CITY OF ALBUQUERQUE

**Re: Boca Negra Dam LOMR
Engineer's Stamp Date –no seal or stamp- (D10D000)**

Based upon the information provided in your submittal received 5-11-15, the following comments are to be addressed:

Drawing file: Boca Negra Arroyo LOMR Jan_2016 / FIRM ANNO-35001C0111G.pdf

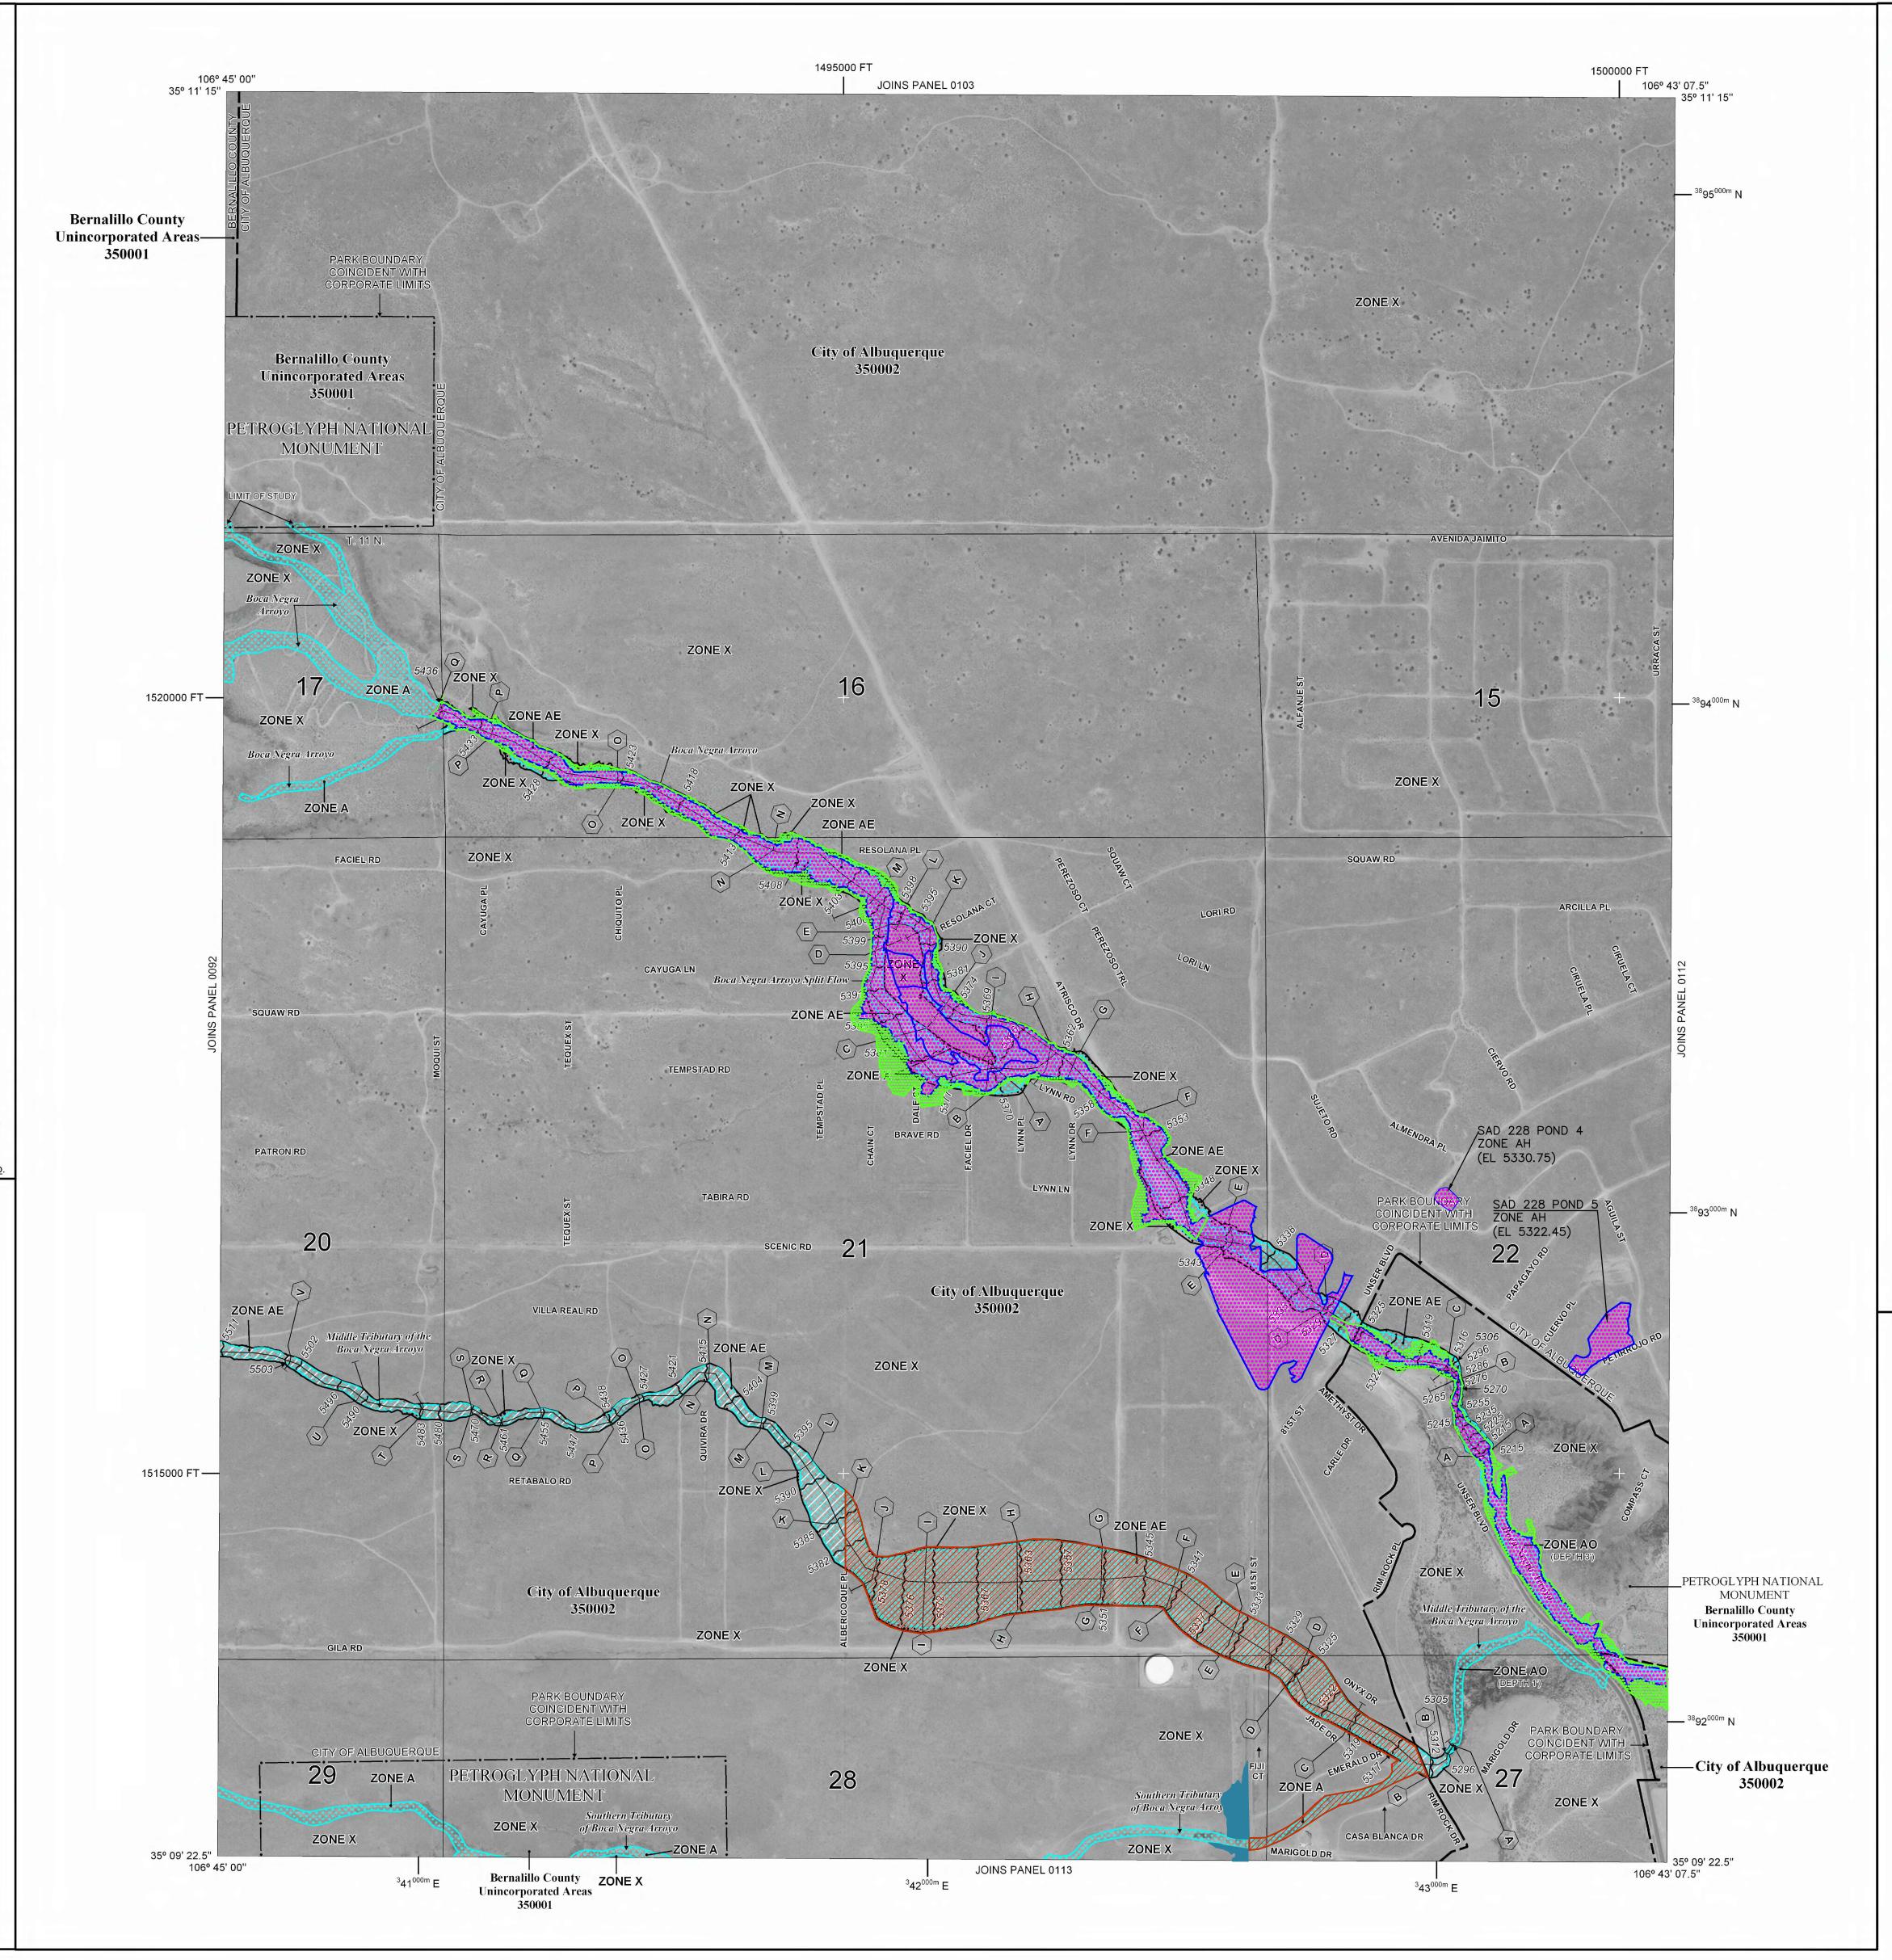
1. The LOMR is not stamped or sealed.
2. "Submitted by" should be AMAFCA, not the City of Albuquerque.
3. The annotated FIRMS are to be labeled "Annotated FIRM".
